Rezoning Transportation Analysis

Petition Number: 2020-088

General Location Identifier: Tax ID 02932106A

Date	Description
07-23-2020	First Review
09-22-2020	Second Review
10-19-2020	Third Review

SHEET NUMBER  
**RZ-1**

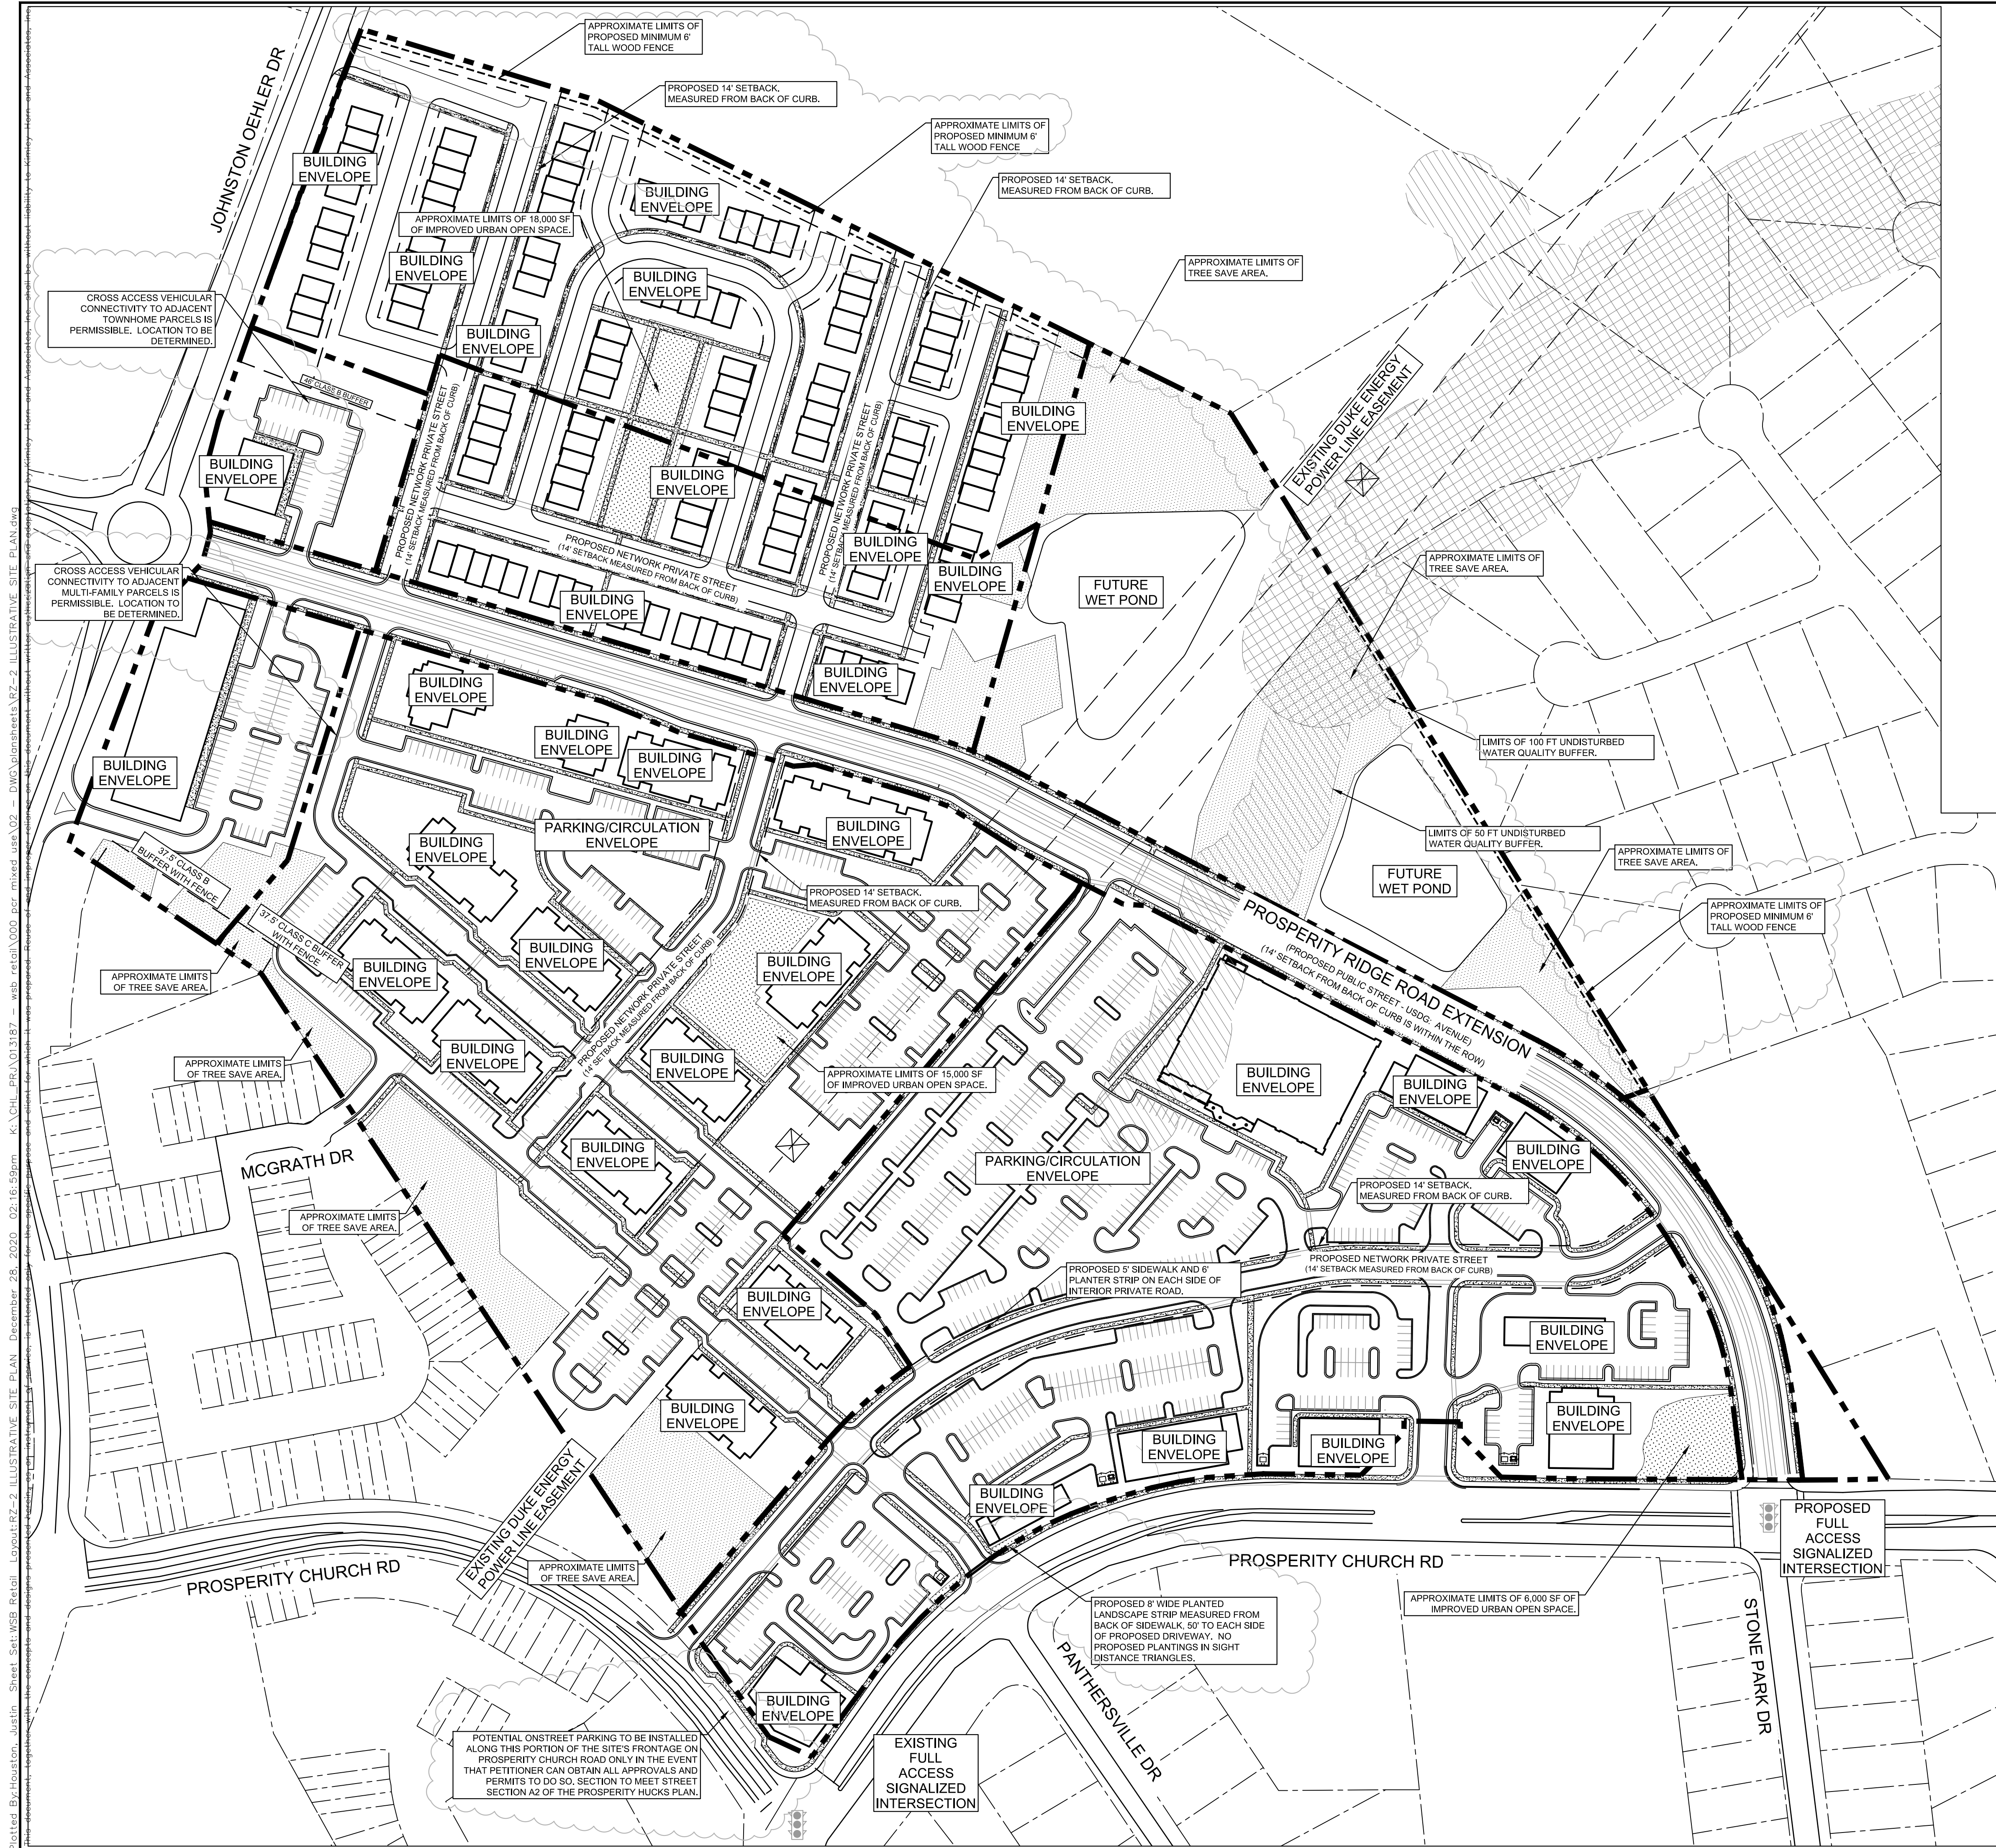
1. **Outstanding (site plan dated 10-14-2020) Curblines** The proposed zoning district has a setback measured from back of the existing or proposed future curblines.
 - a. **Johnston Oehler Drive:** Location of curb and gutter should be placed per A5 below.
 - b. **Prosperity Church Road:** Location of curb and gutter should be placed per A1 below.

The site plan should show the curb and gutter labeled and dimensioned from the centerline for each road.

OPTION 1A: PROSPERITY RIDGE ROAD EXTENSION SECTION WITH BICYCLE LANES (SHOWN WITH ON STREET PARKING WHERE APPLICABLE)

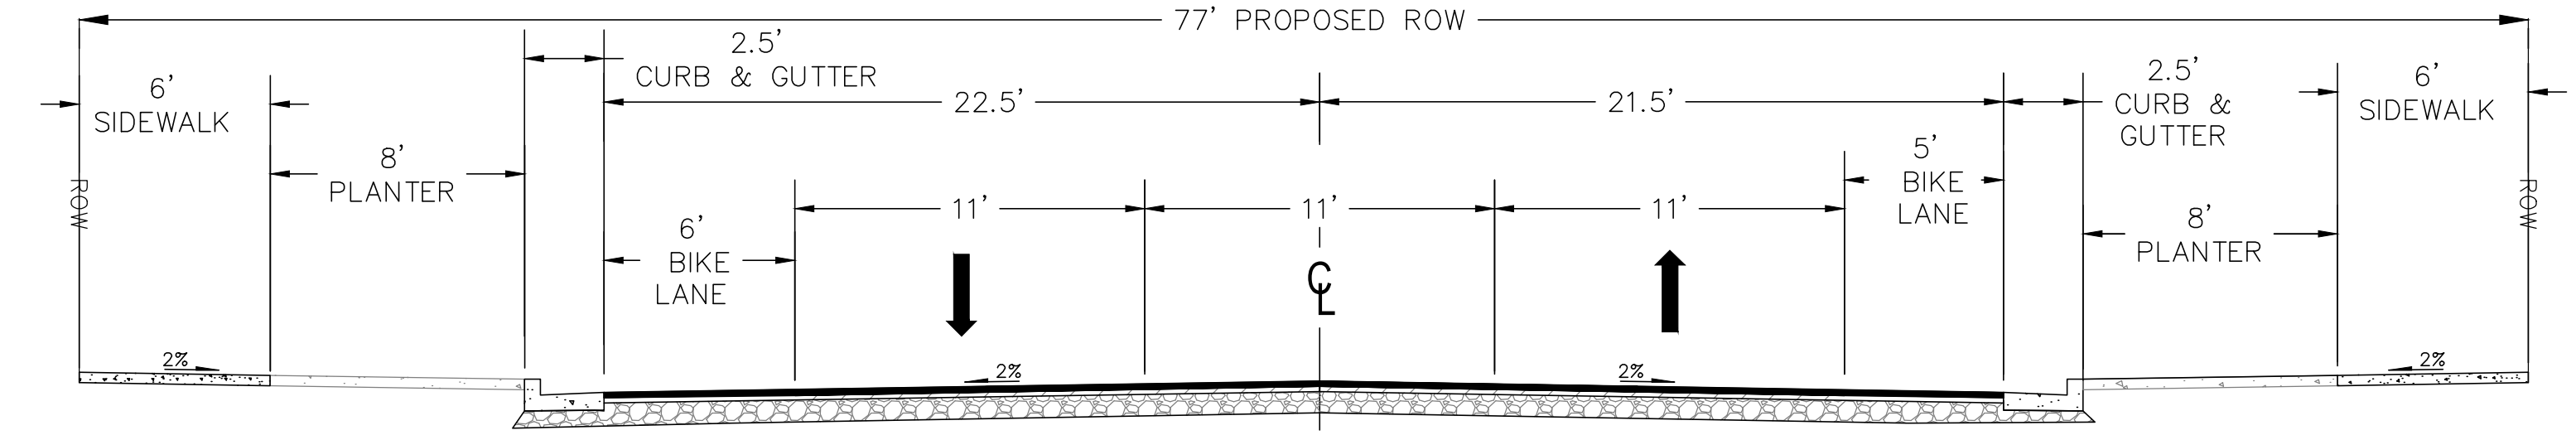
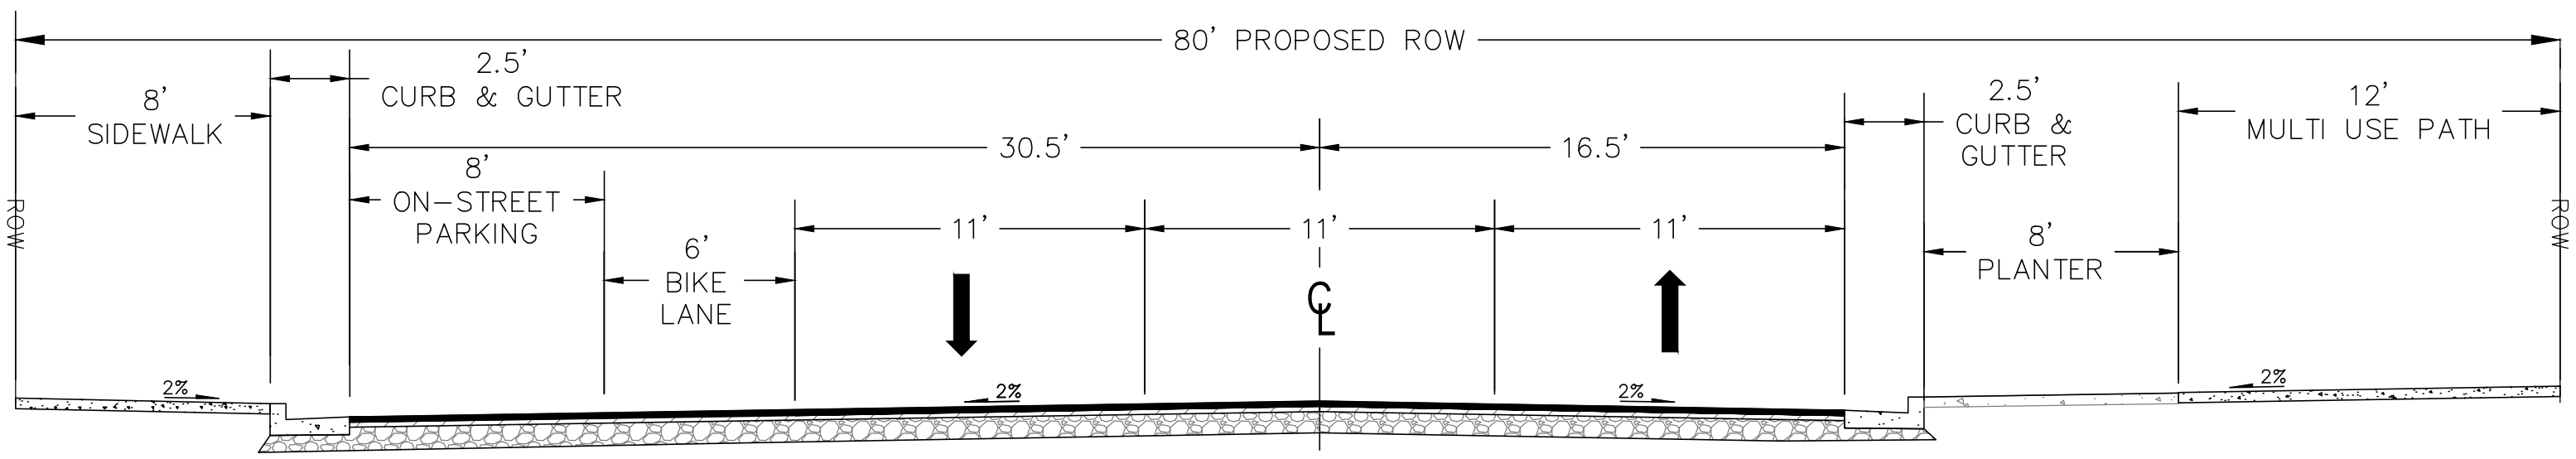
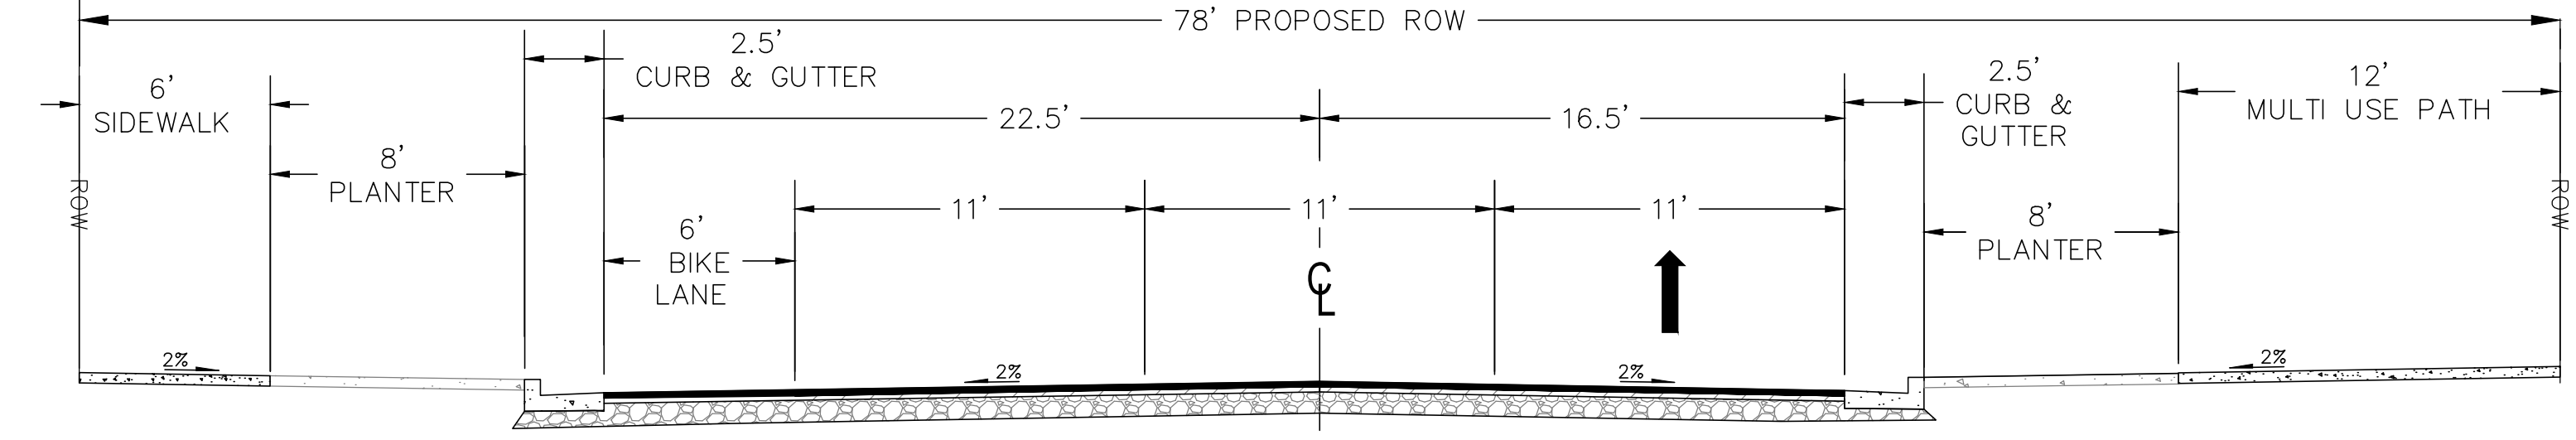
- ~~The petitioner should revise the site plan and conditional note(s) to clarify which USDG street sections are proposed on each internal street.~~
- ~~The petitioner should revise the site plan and conditional notes (Section 3.C. and 5.D.) to include either a planting strip or amenity zone adjacent to on-street parking, in conformance with the Prosperity Hucks Area Plan cross sections.~~
- Outstanding** Increase the width of the bike lanes to 5 ft, in accordance with Charlotte BIKES. The petitioner should revise the site plan and conditional note(s) to revise the Prosperity Ride Road Extension to replace the proposed 4-foot bike lane with a 5-foot bike lane. Please revise the proposed valley gutter shown to a 2.5-foot curb and gutter.

- ~~**Outstanding** Revise the site plan and conditional note(s) to include the recommended improvements, as included within the TIS.~~
- Outstanding** Revise the site plan and conditional note (Section 3.E.) specifying all transportation improvements will be approved and constructed before the site's first building certificate of occupancy is issued. Alternatively, the petitioner may phase transportation improvements if said improvements and phasing are explicitly described in site plan notes or as listed within the approved TIS.
- New comment (site plan dated 10-14-2020):** The petitioner should revise the updated Prosperity Ridge Road Extension cross section to include two separate cross sections with and without on-street parking. The proposed typical cross section places the curb and gutter at the incorrect location, if on-street parking is provided.
